COLORADO GEOLOGICAL SURVEY

May 1, 2017

Subject: Crystal Park Filing 2, Lot S-184 (184 Camelot Road)
File Number unassigned; El Paso County, CO; CGS Unique No. EP-17-0049

Colorado Geological Survey has reviewed the Crystal Park Site 184 referral. We understand a single family home is proposed on approximately 0.7 acre located within the Crystal Park PUD. With this referral, we received a Geologic Hazard Report by RMG dated March 3, 2017, and a Concept Site Plan by Virginia Ownbey (February 8, 2017).

CONCEPT SITE PLAN
CRAIG & DEBRA GARDNER
 S-184 M328
 PLANNING BY VIRGINIA OWNBEY
 FEBRUARY 8, 2017 1"=40'

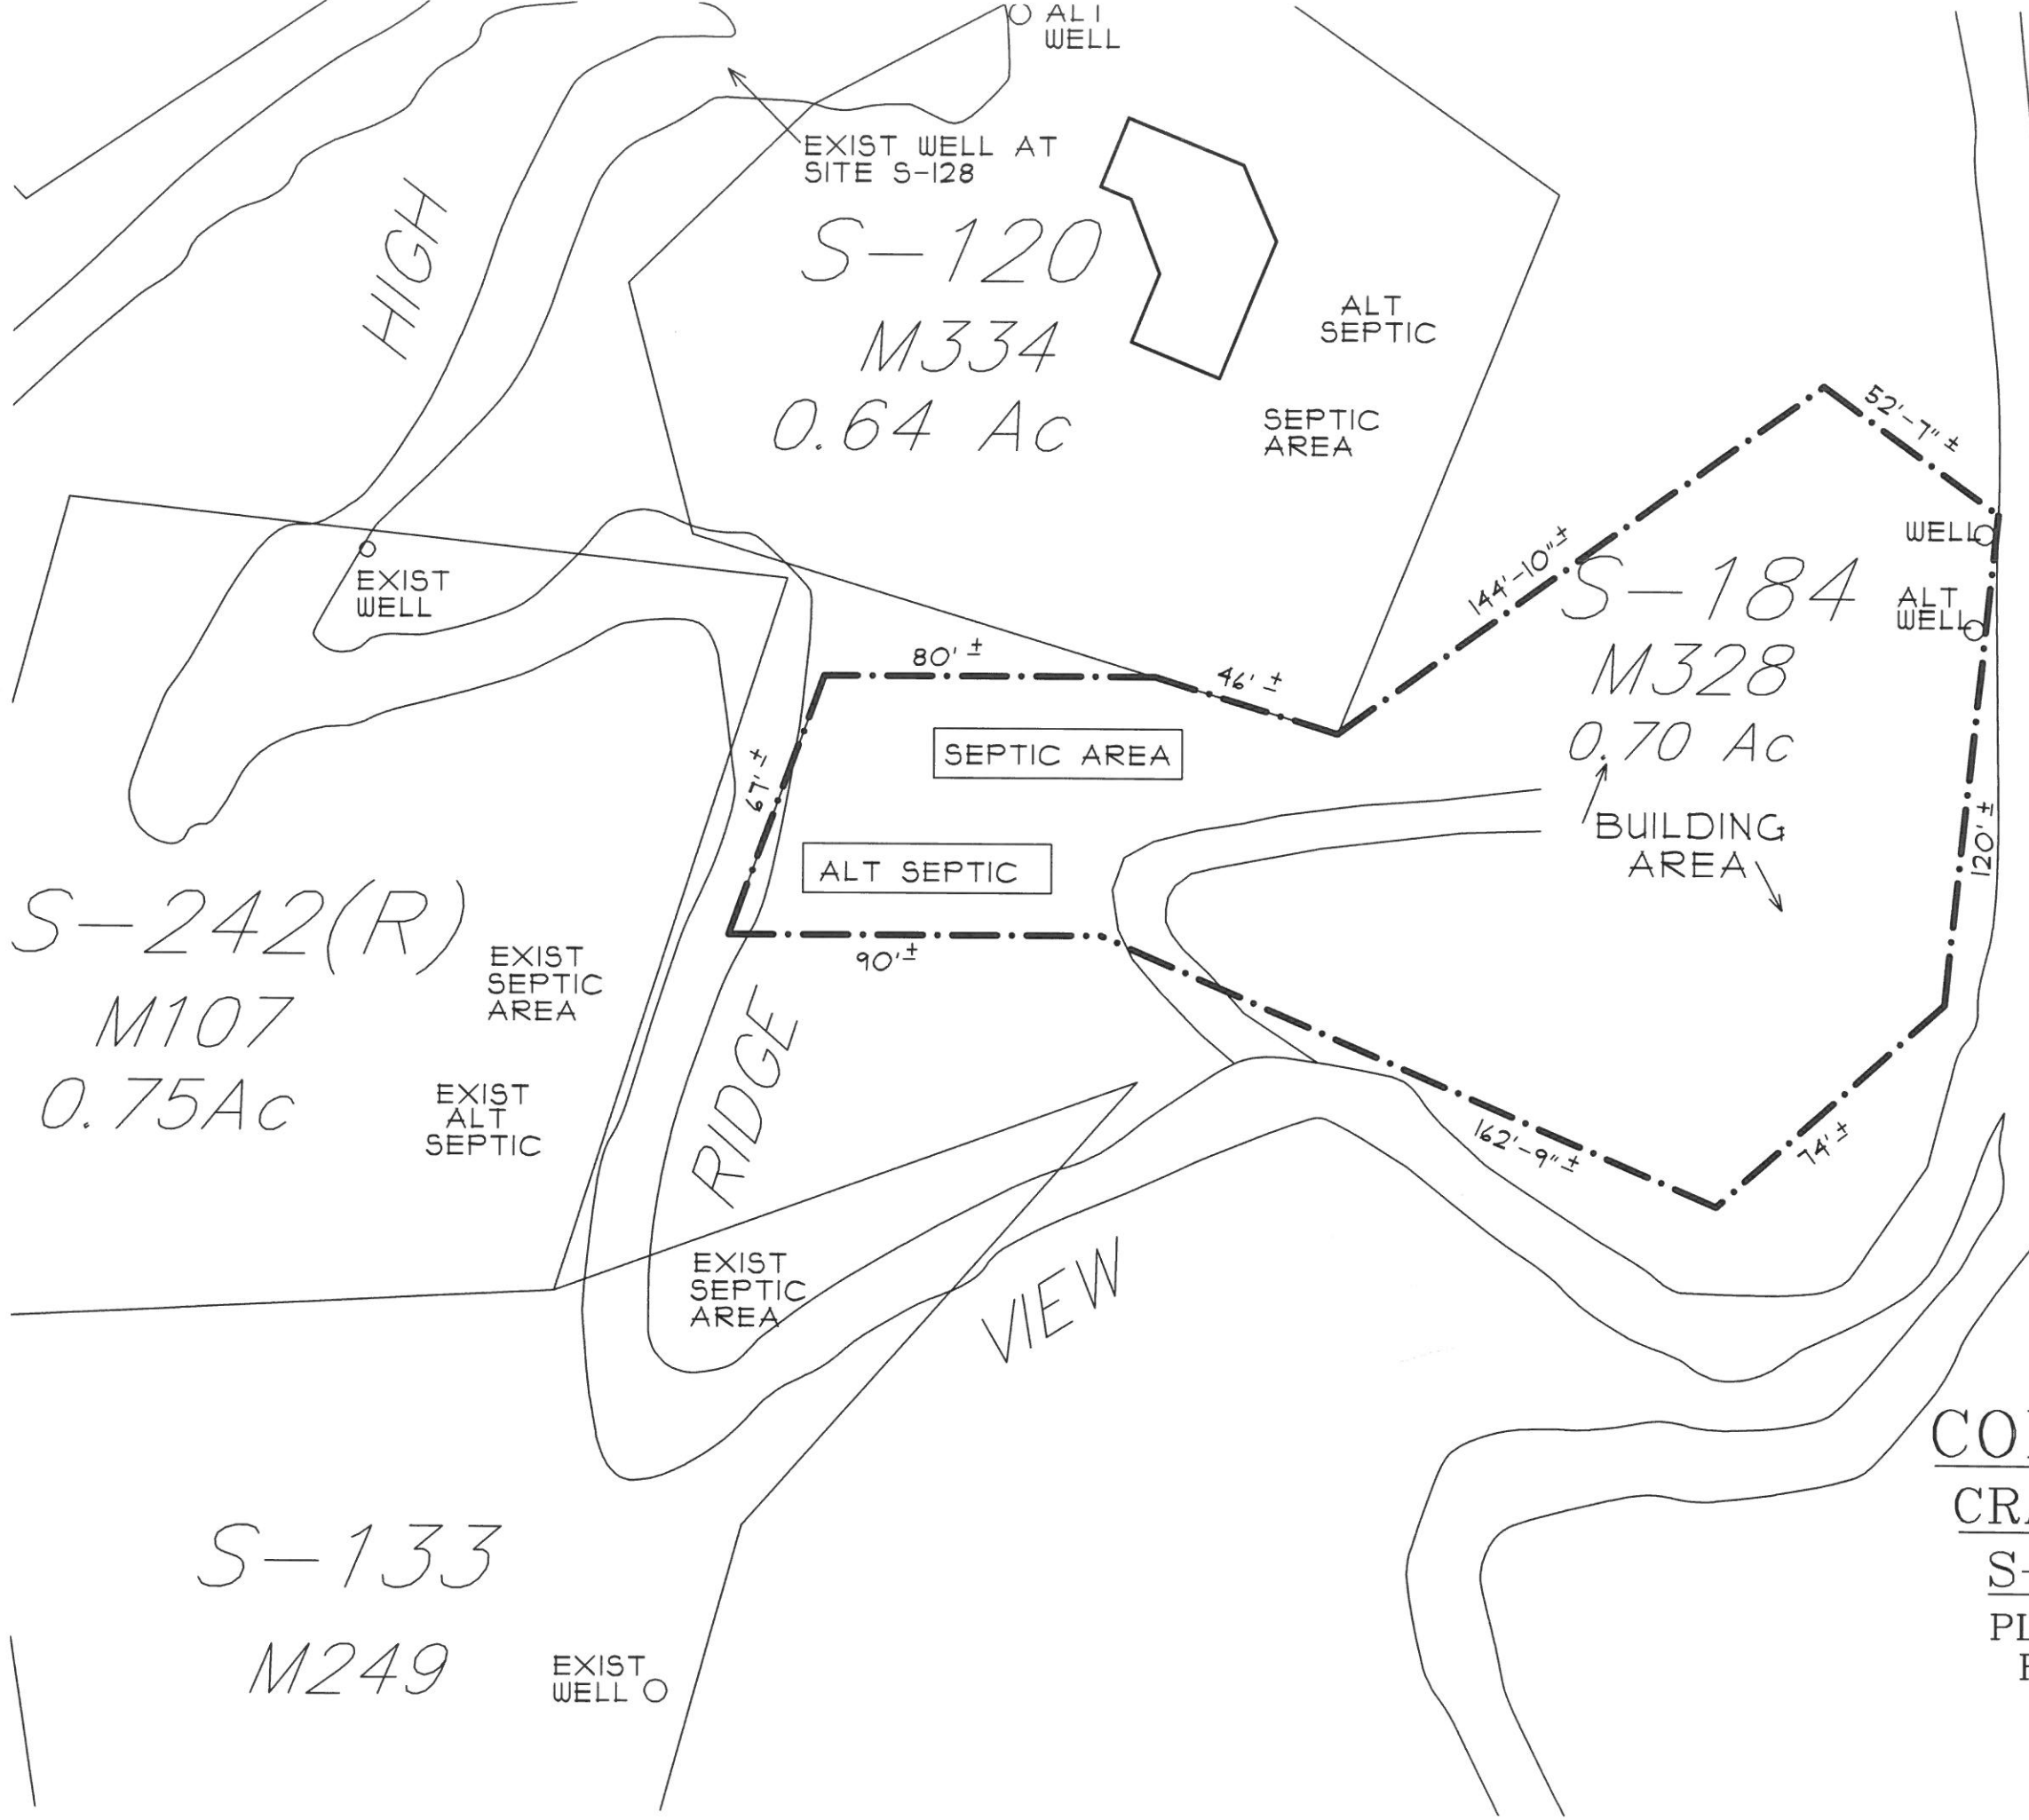
CGS visited the site on April 25, 2017. There appears to be a suitable building site that avoids slopes of $\geq 30\%$ at the end of the driveway shown on Ownbey's Concept Site Plan. **CGS agrees with RMG that the site does not contain, nor is it exposed to, any geologic hazards that would preclude the proposed lot and residential use.** However, we have several comments:
